Advice to decision maker on coal mining project

IESC 2021-125: Boggabri Coal Mine Modification 8 (EPBC 2021/8875, MP 09_0182 MOD 8) – Expansion

Requesting agency	The Australian Government Department of Agriculture, Water and the Environment The New South Wales Department of Planning, Industry and Environment
Date of request	23 July 2021
Date request accepted	23 July 2021
Advice stage	Assessment

Figure 3 | Incremental drawdown – Alluvium (Source: AGE, 2022)

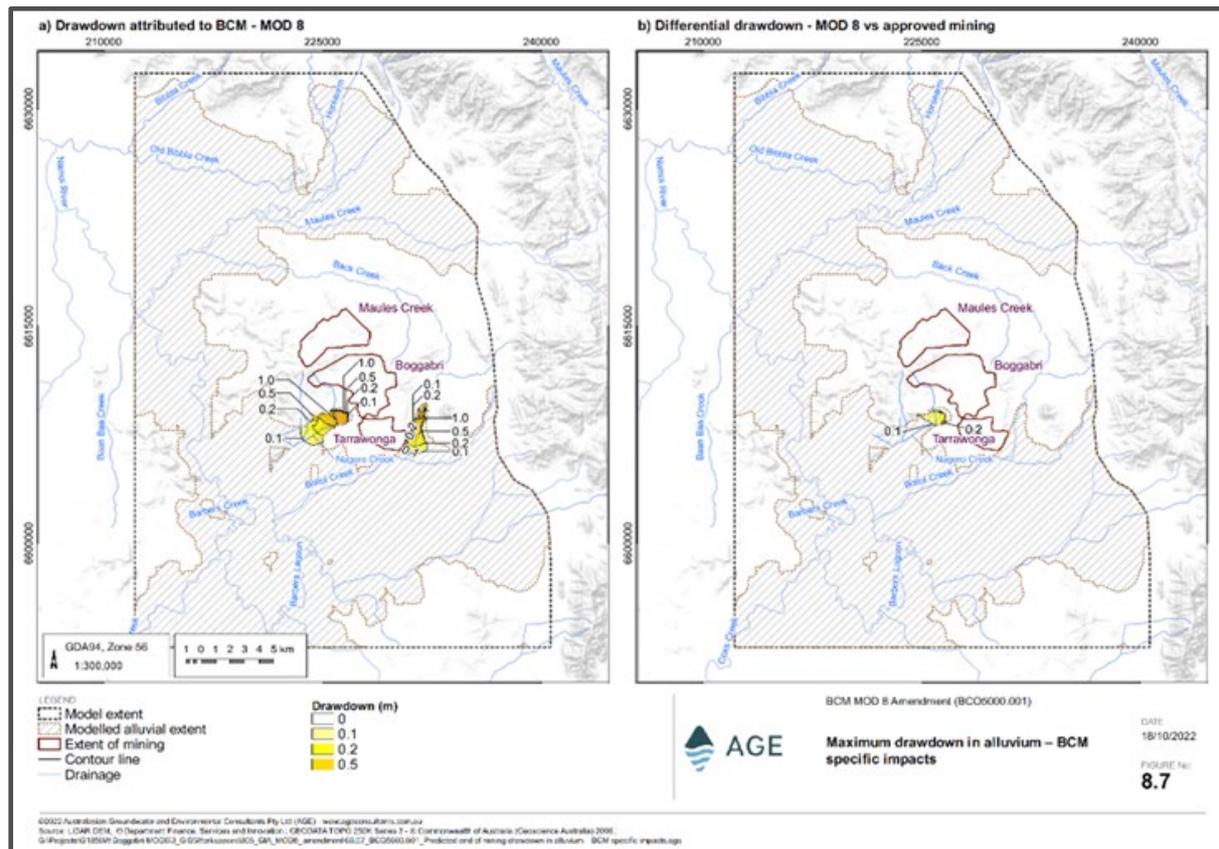
- d. Further interrogation of the groundwater model is needed to evaluate how predicted drawdown from the project may alter surface water-groundwater interactions in Nagero, Bollol and Goonbri creeks (including the extent and magnitude of reach-specific patterns of groundwater discharge and recharge) and ecologically important components of their flow regimes (Paragraph 14).

3. Although the project is not expected to result in a pit lake, the area is predicted to act as a long-term recharge source to the alluvial tongue of Nagero Creek (Hansen Bailey 2021, App. H, p. 78). To improve confidence in prediction of the potential impacts (Paragraph 7) of alterations to the magnitude and extent of this long-term recharge to GDEs, the proponent should discuss how recharge will vary during and after the project and how this might alter groundwater levels in the alluvium in addition to the predicted drawdown.

Figure 4 | Cumulative drawdown – Alluvium and GDE (Source: AGE, 2022)

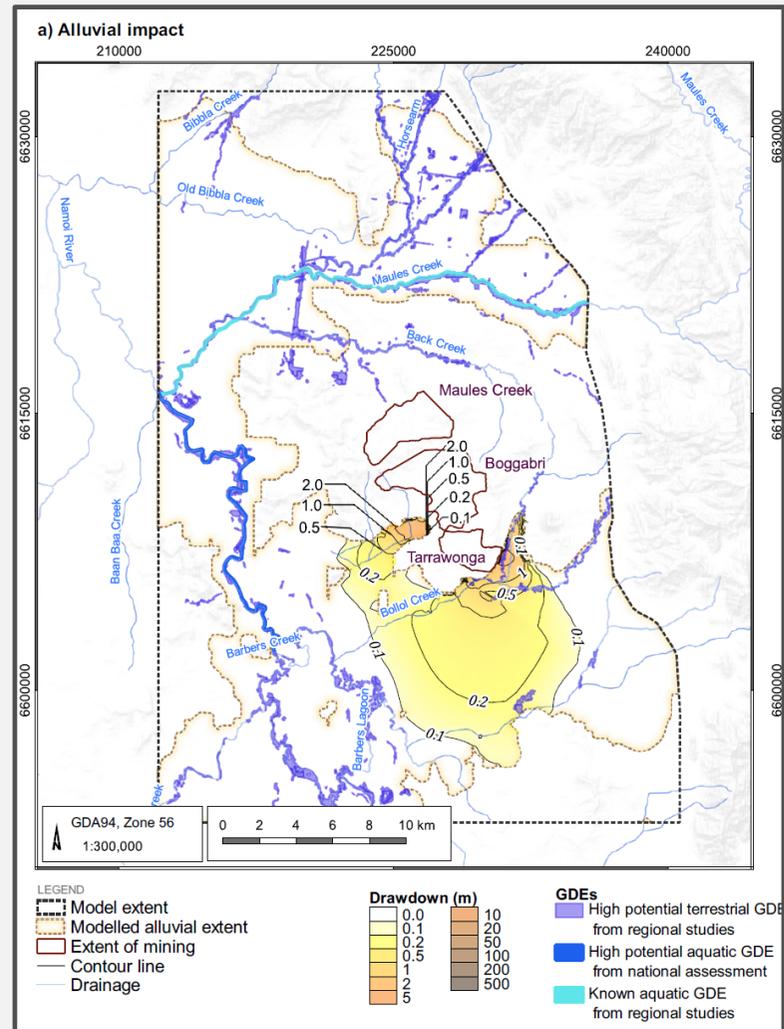
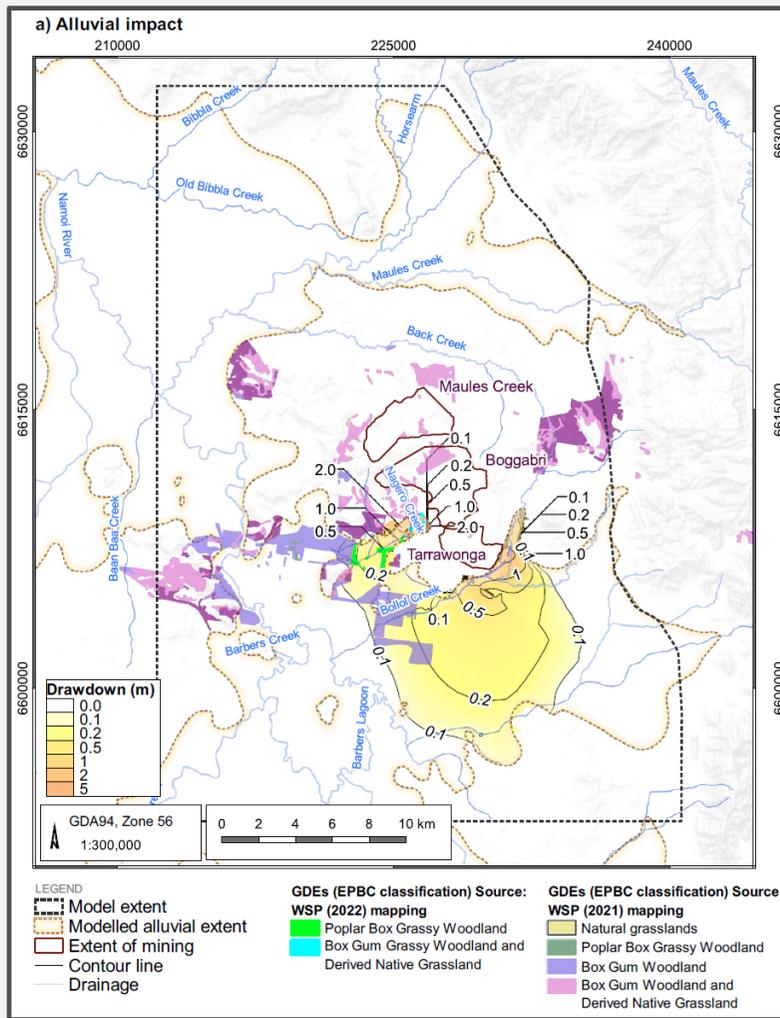
- b. Cumulative impacts are likely to have been underestimated because the model provides an assessment of the impacts of the BMT Complex only. Of particular concern are potential cumulative impacts associated with the Tarrawonga Modification 7 Project (not included as the Tarrawonga Modification 7 Project was approved after the AGE (2020) model was finalised) and the Vickery Mine (whose cumulative impacts of the Vickery Mine were considered unlikely by the proponent (Hansen Bailey 2021, App. H, App. A, p. 4)). In addition, the IESC notes that the Maules Creek Modification 7 Project was approved in August 2021, which allows for an increase to the existing out-of-pit rock emplacement landform. It is recommended that all relevant projects be included in the groundwater model to improve predictions of the cumulative impacts of the project.

13. Drawdown of up to 5 m is predicted adjacent to Nagero and Goonbri creeks, and up to 1 m adjacent to Bollol Creek (Hansen Bailey 2021, App. H, Fig. 8.3). This drawdown could impact terrestrial GDEs in the area (Hansen Bailey 2021, App. Q, p. 41), including *Melaleuca bracteata* and *Eucalyptus populnea* (a Koala feed-tree species) (Hansen Bailey 2021, App. Q, p. 35). In addition, the proponent notes that the study area may be used as a wildlife corridor through the broader landscape (Hansen Bailey 2021, App. P, p. 102). Several additional monitoring and/or mitigation measures are suggested to improve the assessment of potential effects of drawdown associated with the project.

Figure 5 | Nagero Creek – Terrestrial GDE (Source: AGE, 2022)

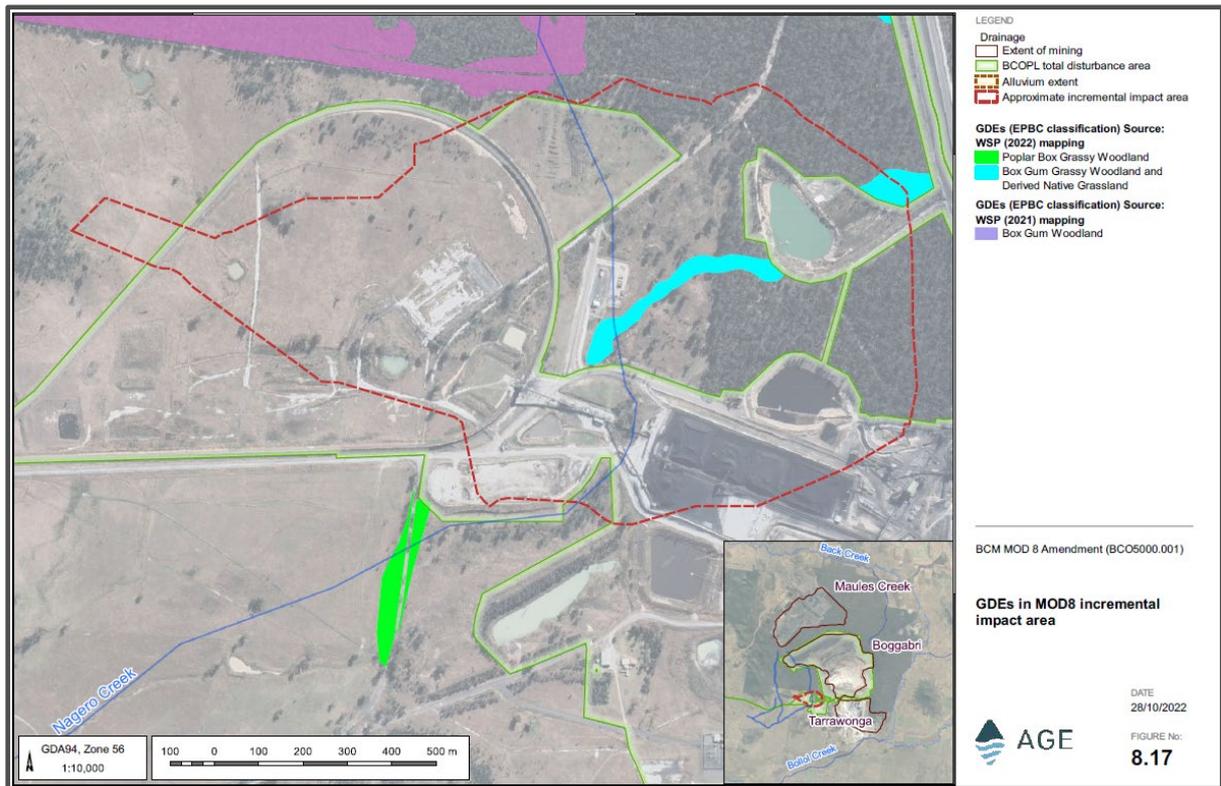
- a. Direct field measurements of groundwater use by vegetation should be undertaken in areas of predicted drawdown, especially for riparian vegetation associated with Nagero, Bollol and Goonbri creeks (e.g. Doody et al. 2019). In particular, groundwater dependence of vegetation in PCT 599 (Blakely's Red Gum-Yellow Box grassy tall woodland) lining part of Nagero Creek should be assessed because this potential GDE is EPBC Act-listed as critically endangered. Where these measurements indicate dependence on groundwater, appropriate monitoring and mitigation measures should be developed.

- b. The IESC notes that an unverified population of Poplar Box Grassy Woodland on Alluvial Plains (listed as Endangered under the EPBC Act) occurs on the alluvial tongue of Nagero Creek and may be impacted by the project (Hansen Bailey 2021, App. Q, p. 42). This population's identity should be field-verified and its groundwater-dependence assessed.
